Addition of first floor to form self-contained flat, change of use of existing leisure use (D2 Assembly & Leisure) to office use (A2 Financial & Professional Services) at ground floor & external alterations.

1 Arcade Road Littlehampton

164.2 Planning Application LU/310/18/PL, 1 Arcade Road, Littlehampton

PROPOSED ALTERATIONS + EXTENSION / ELEVATIONS AS PROPOSED

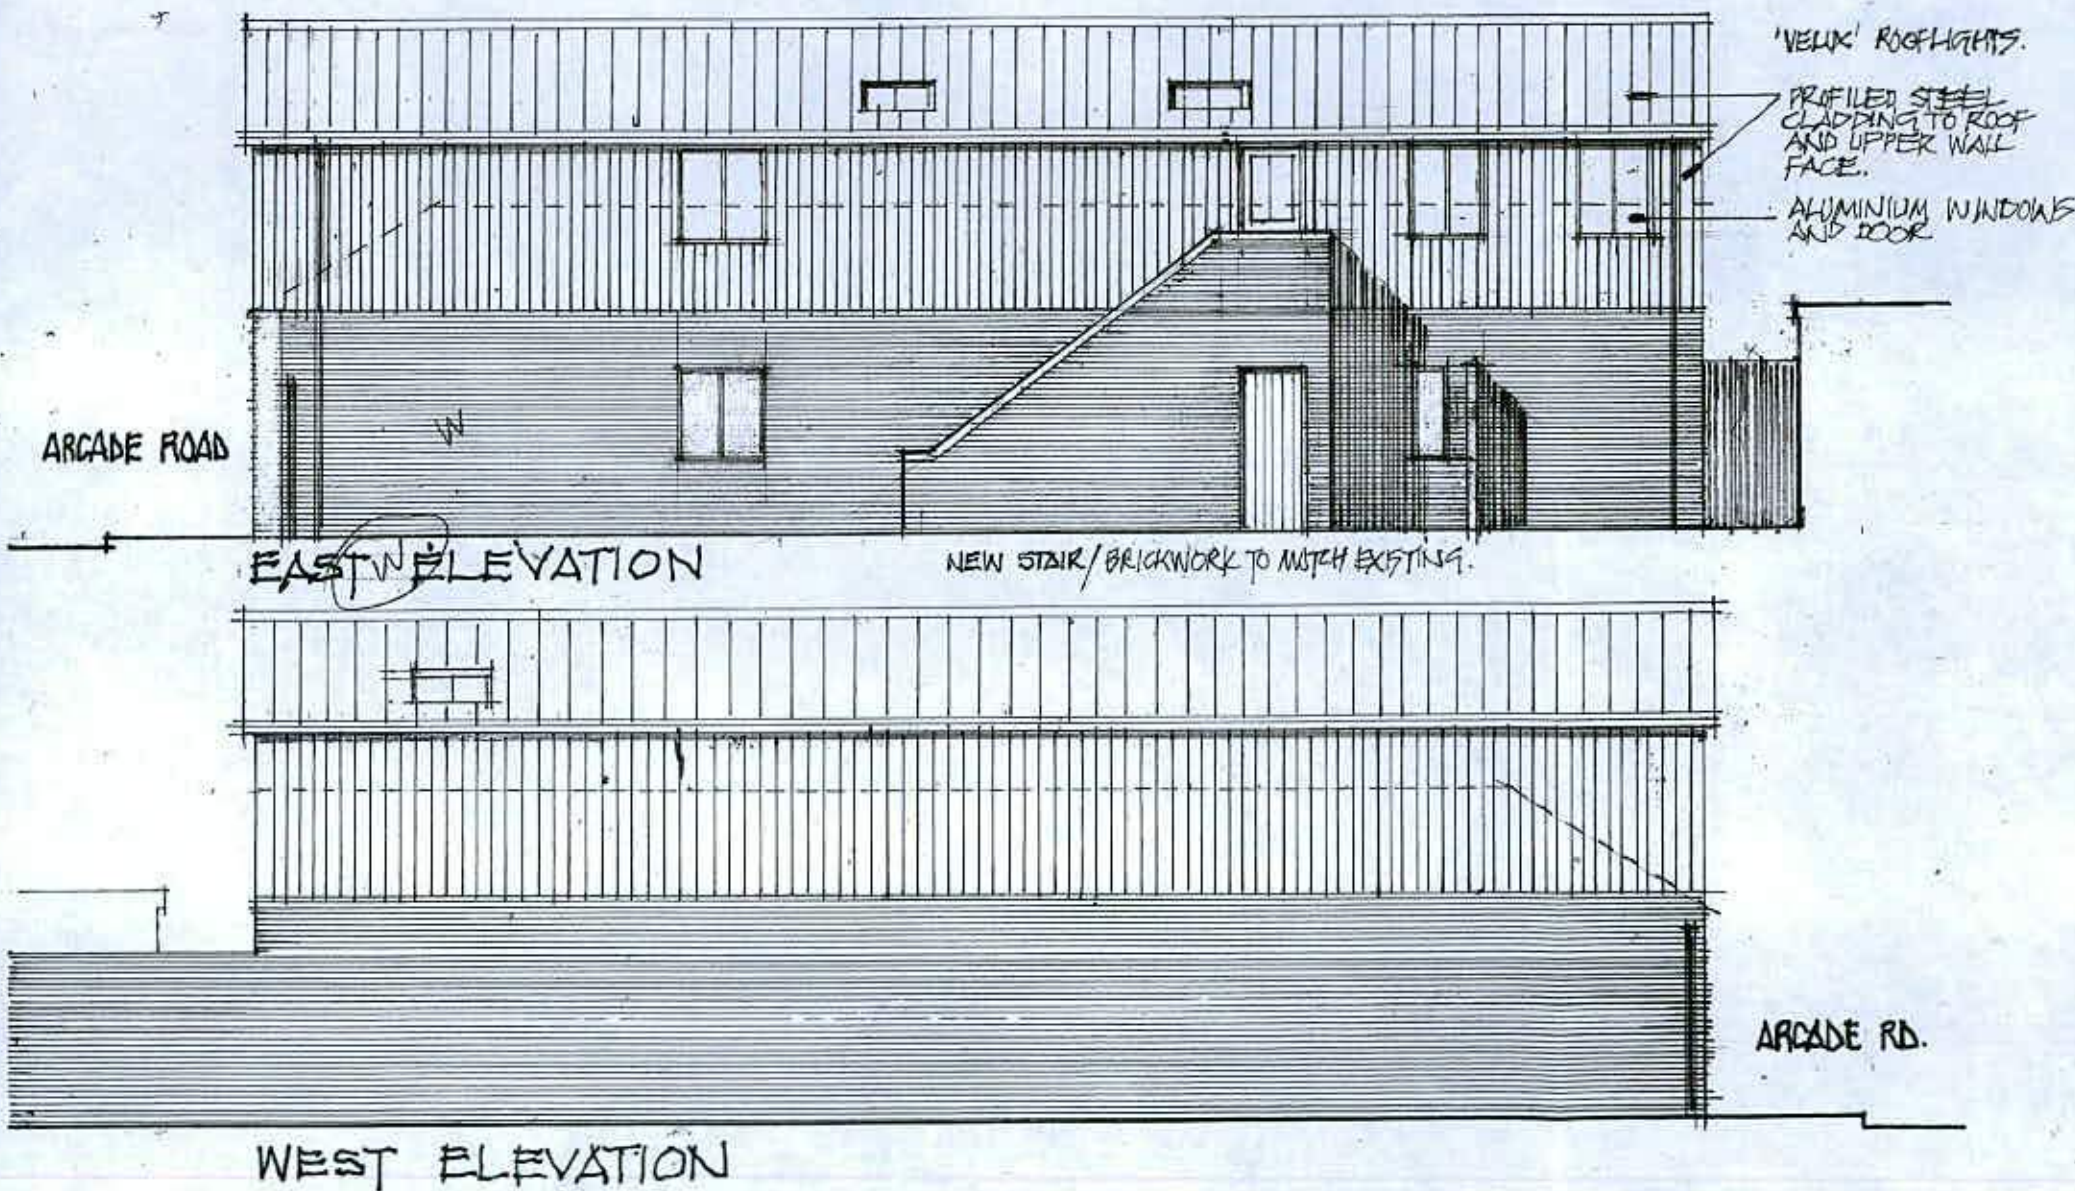
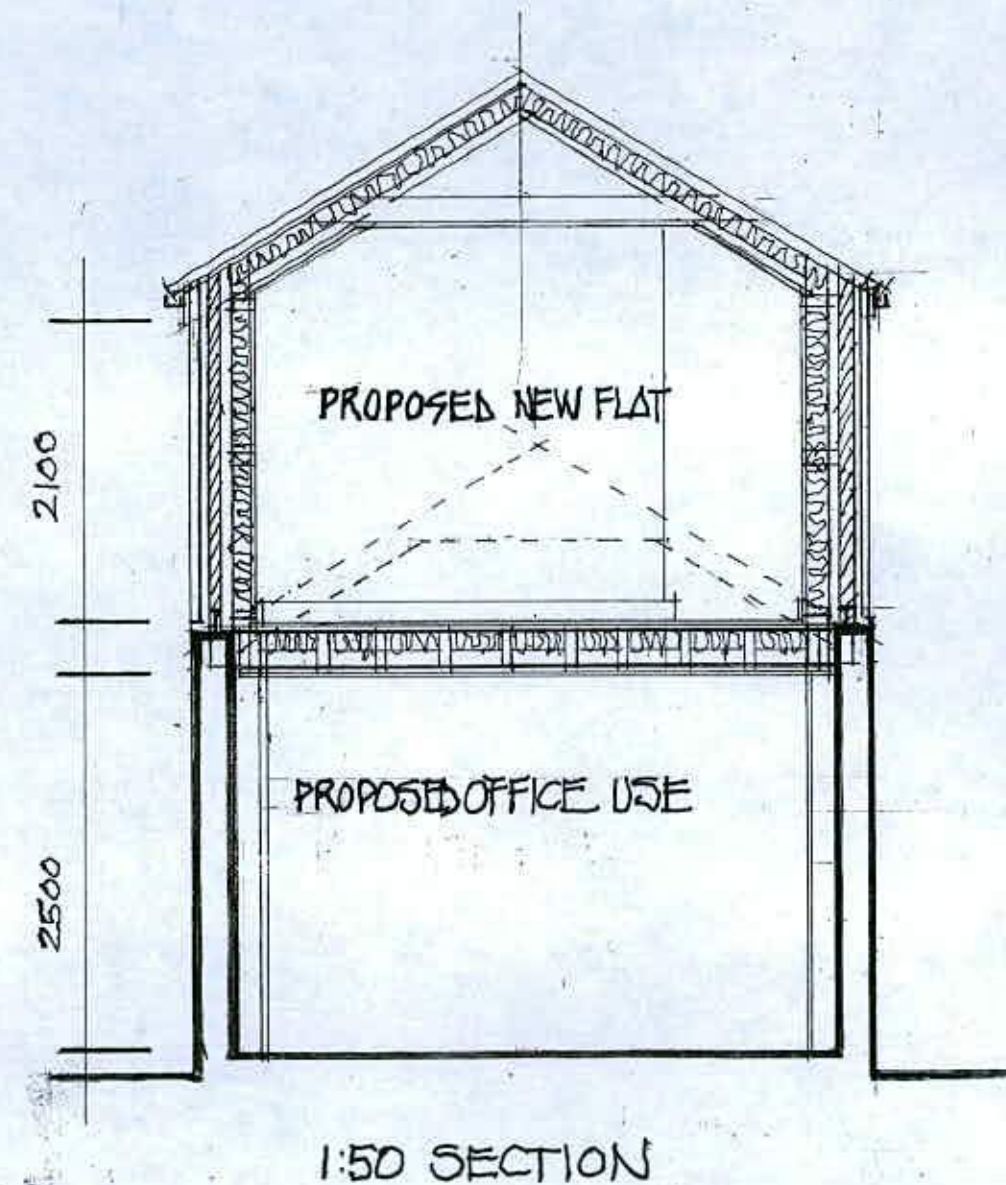
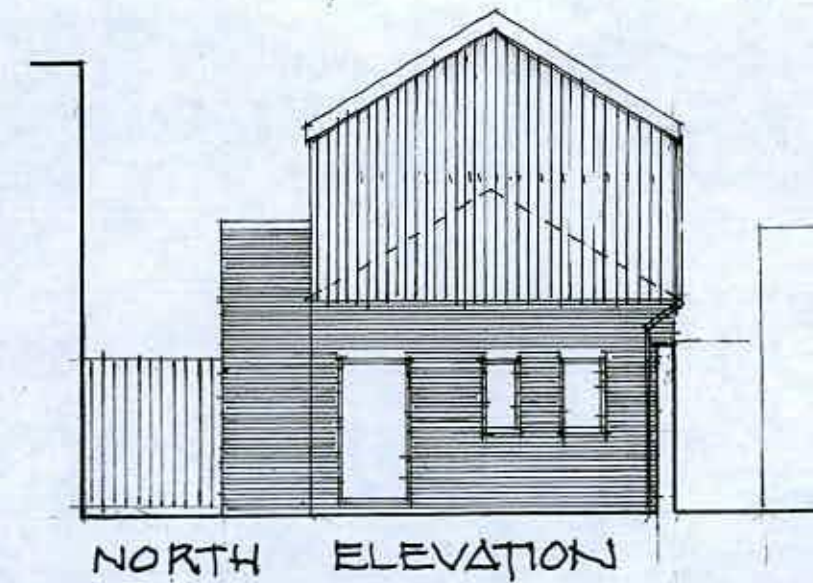
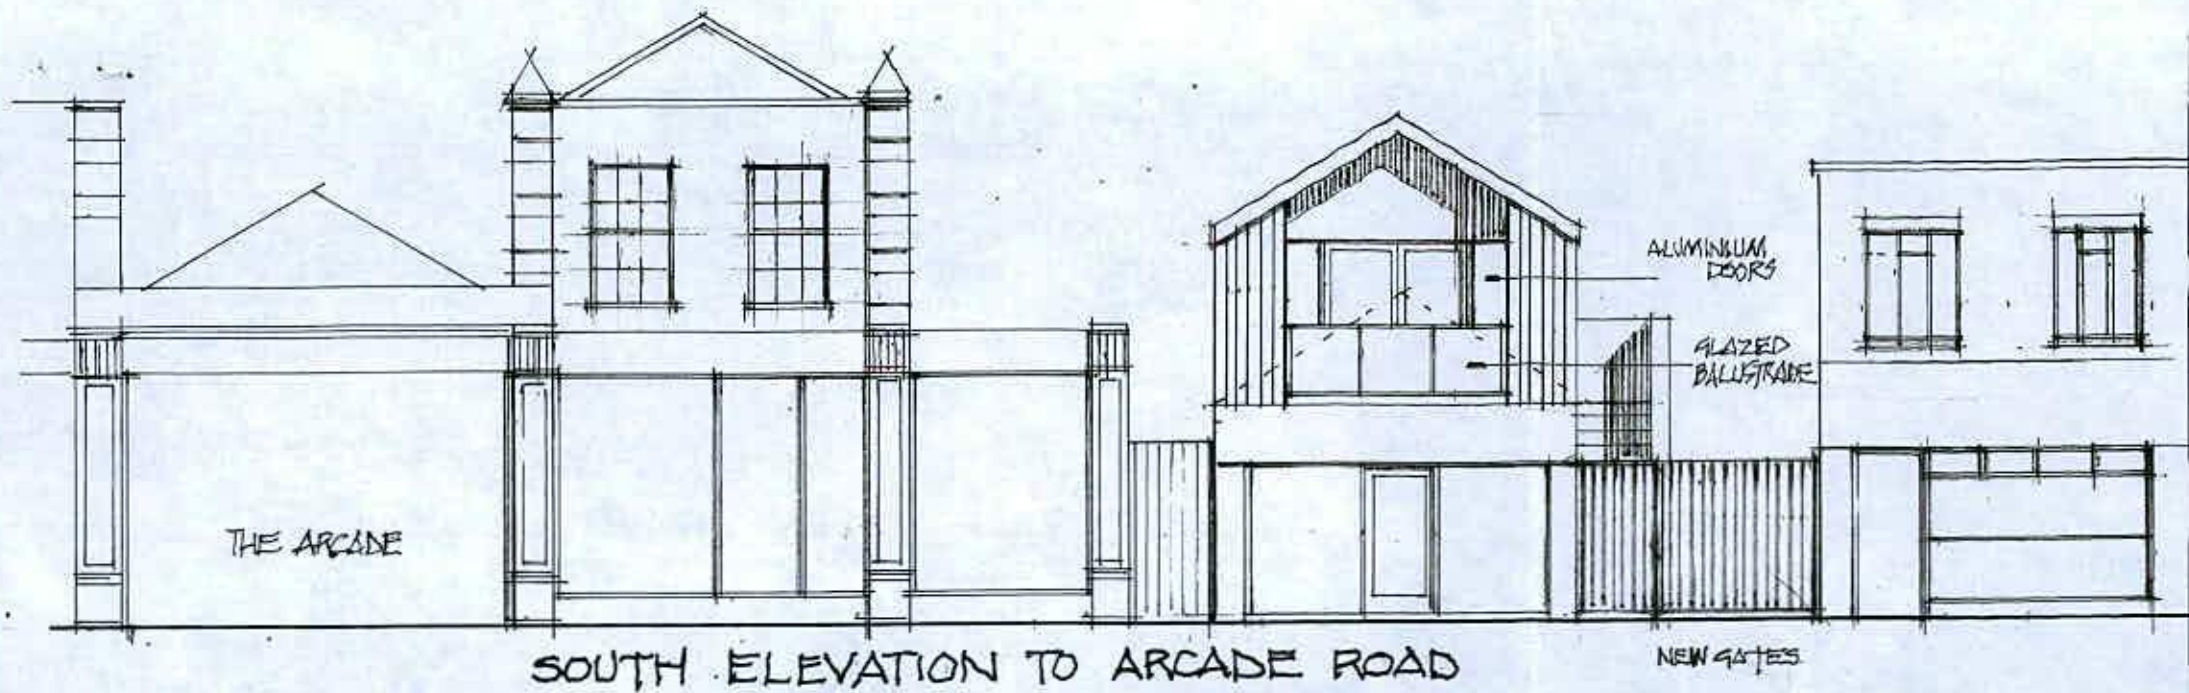
In light of the response to this application received from the Environment Agency (EA), the Committee was requested to withdraw its objection to this application. Observing that the EA considered the scheme acceptable, Members proceeded to review the application. In view of the proximity of the proposed development to a listed building Members supported the comments of the Conservation Area Officer regarding materials. The Committee was therefore content to withdraw its objection and urged the Planning Authority to impose a condition to ensure that the materials used in the scheme reflect the character of buildings found in the surrounding area. It was therefore RESOLVED that:
